Planning Application Ref: FG/162/17/PL

Location : 1 Upper West Drive, Ferring

Description of works: Demolition of existing detached garage & erection of 1 No dwelling

Comments On Application:

1 Upper West Drive, Ferring
Tree Protection Plan

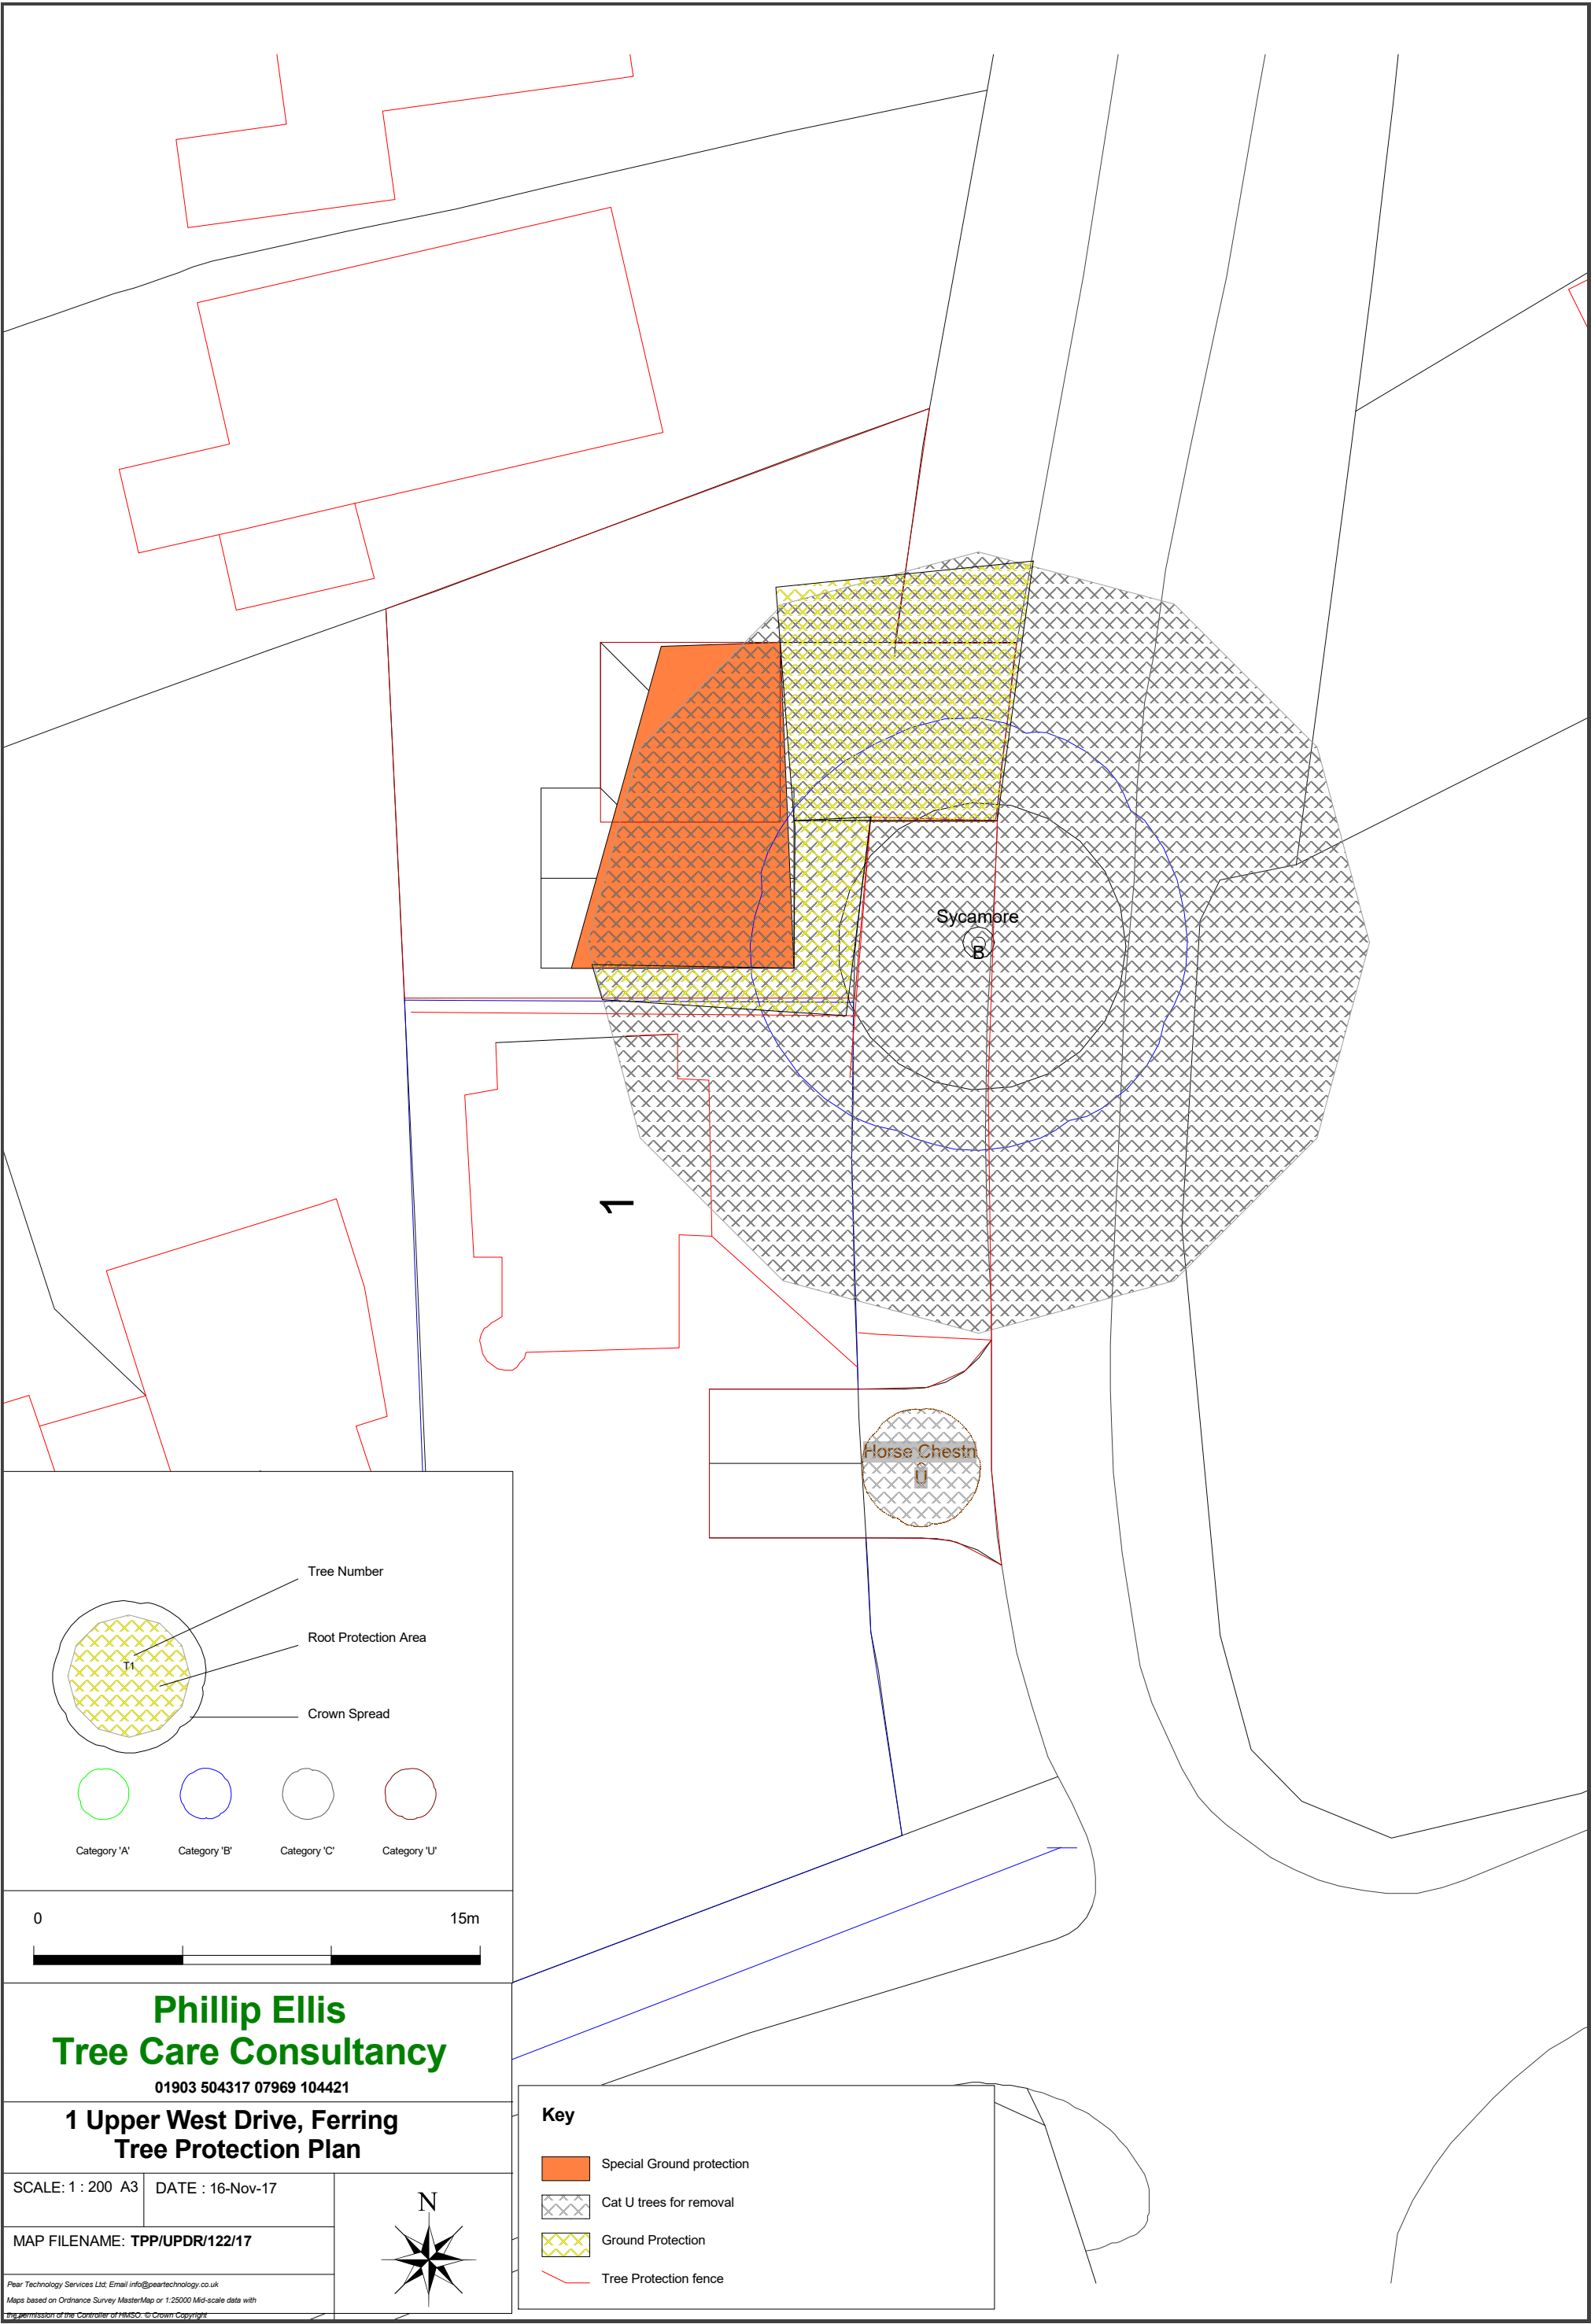
- The applicants Architects report has acknowledged that the RPA overlaps the footprint of the new build but has simply said that a 'suitable foundation system will minimise the damage to the existing root system'.
- However, one key element is missing in that the protective fencing is shown to be hard up against the new building and in this position it would hinder the construction process.
